Proposal:	Proposed two storey side extension and single storey rear extension.
Location:	26 Holden Street Clitheroe BB7 1LU
Grid Ref:	374676 - 441901

With regard to your letter dated the 6th November 2015

Proposed Site Plan 1:200

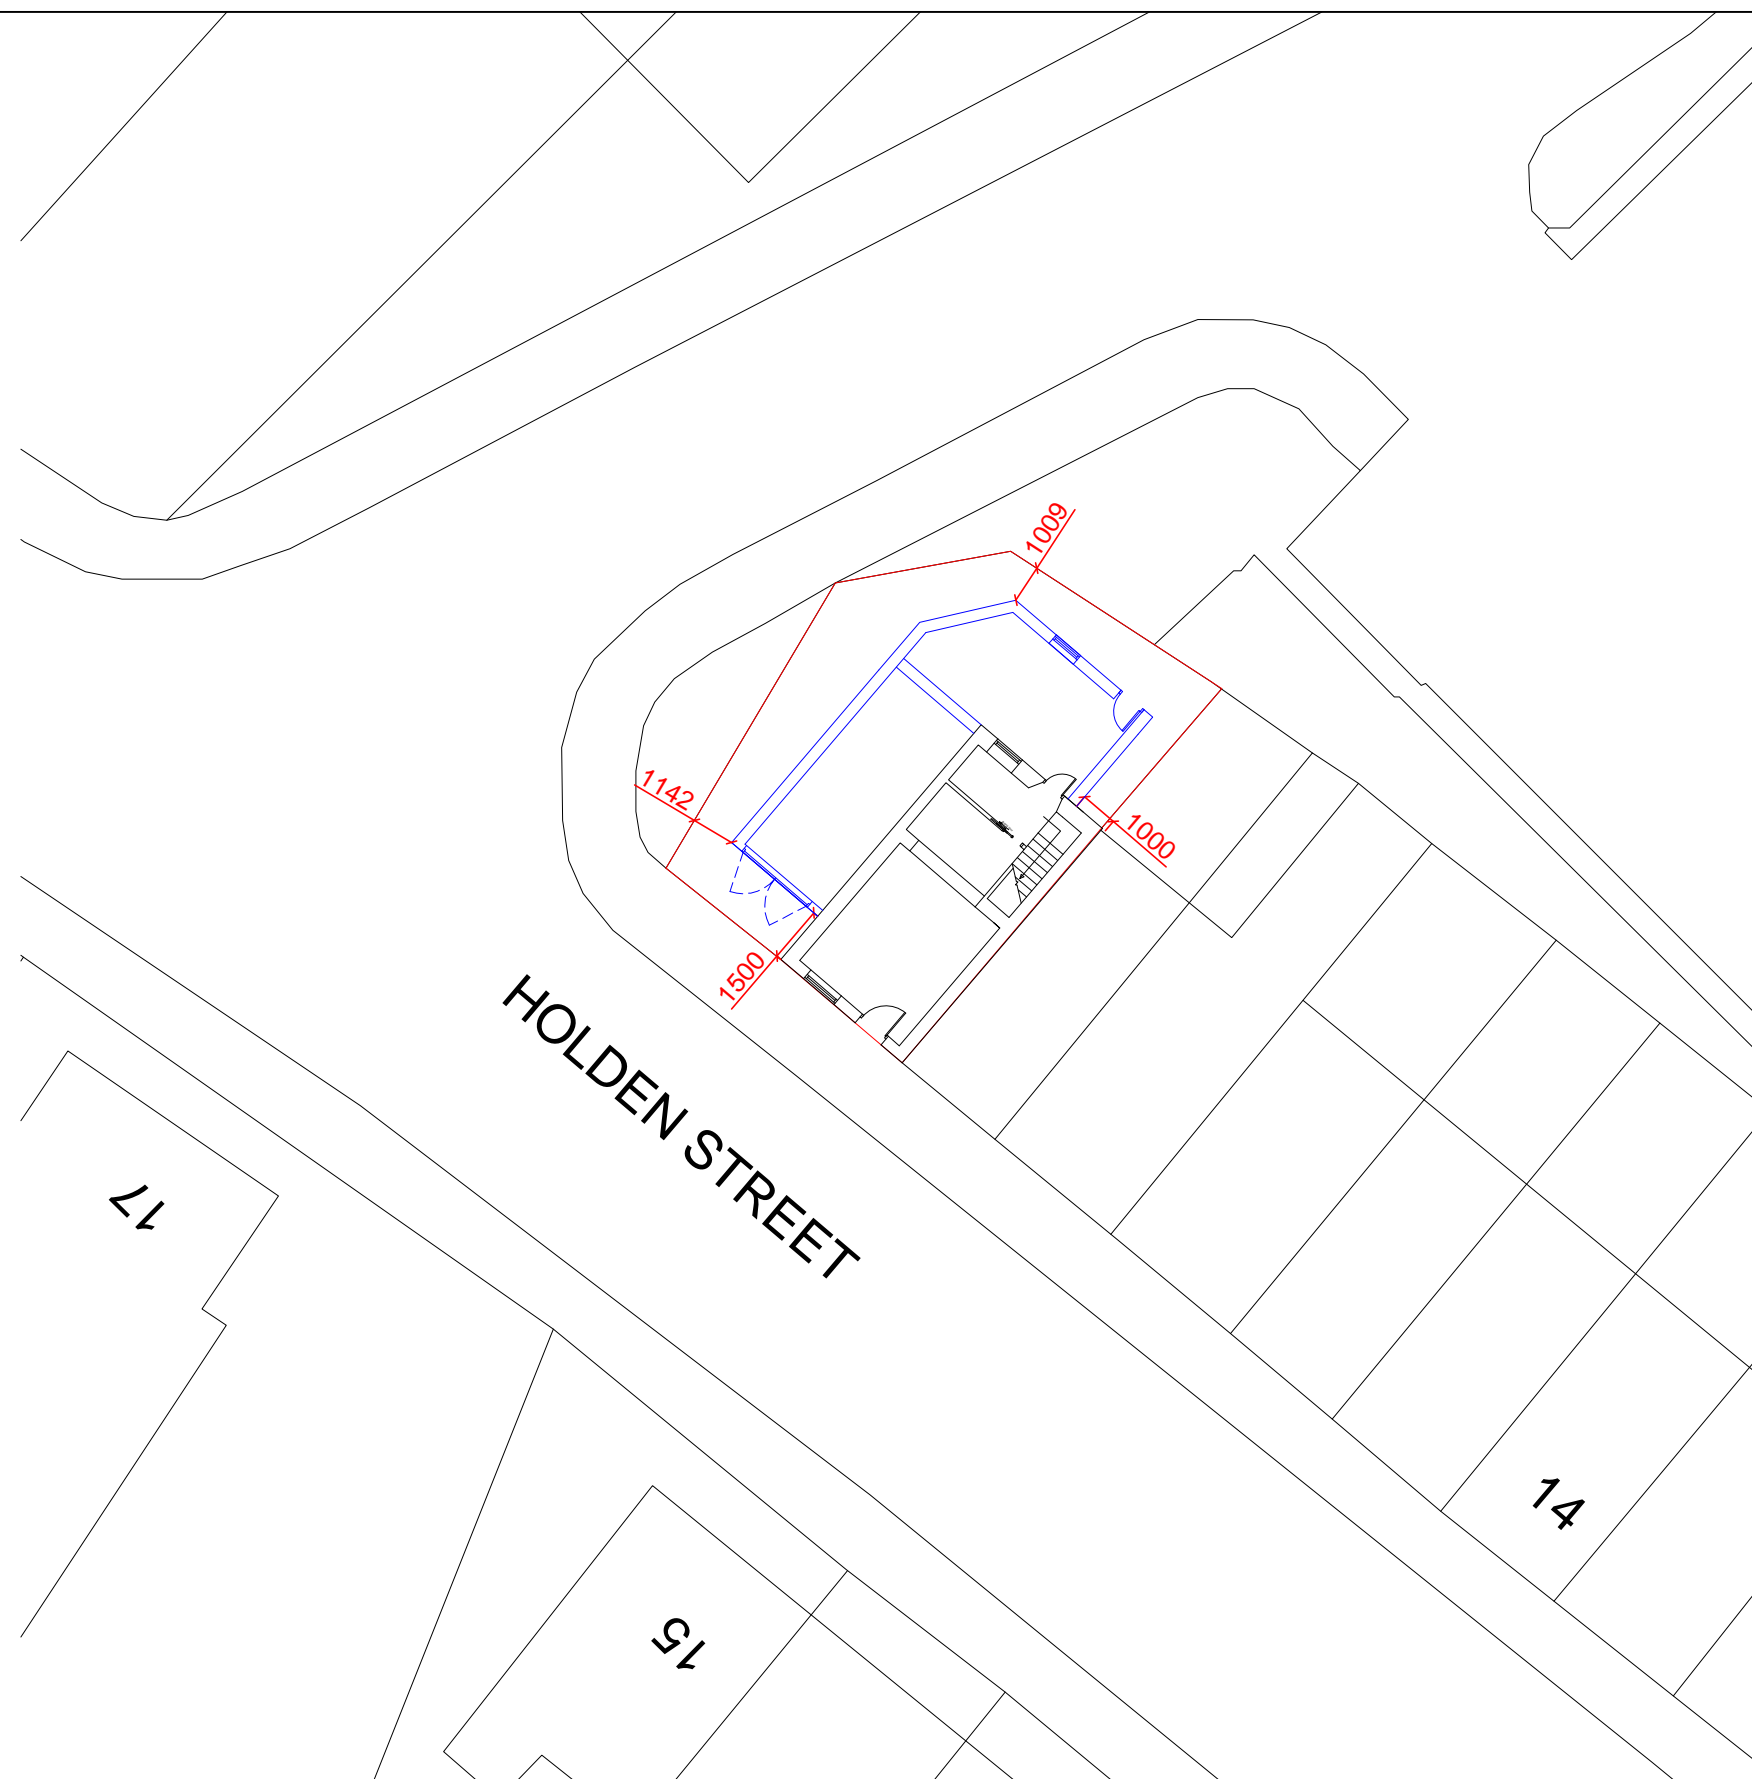
Based on the Joint Lancashire Structure Plan the Highway Development Control Section is of the opinion that the applicant has adequate parking provision off-road and fronting the property. Providing the garage is conditioned to be used as a parking area for perpetuity.

1. The car parking and manoeuvring scheme to be marked out in accordance with the approved plan, before the use of the premises hereby permitted becomes operative and permanently maintained thereafter. Reason: To allow for the effective use of the parking areas.
2. Notwithstanding the provisions of the Town and Country Planning (General Development Procedure) Order 1995 and the Town and Country Planning (General Permitted Development) (Amendment) (No 2) (England) Order 2008, or any subsequent Orders or statutory provision re-enacting the provisions of these Orders, all garages shown on the approved plan shall be maintained as such and shall not be converted to or used for living accommodation without the prior written approval of the Local Planning Authority in consultation with the Highway Authority. Reason: To allow for the effective use of the parking areas.
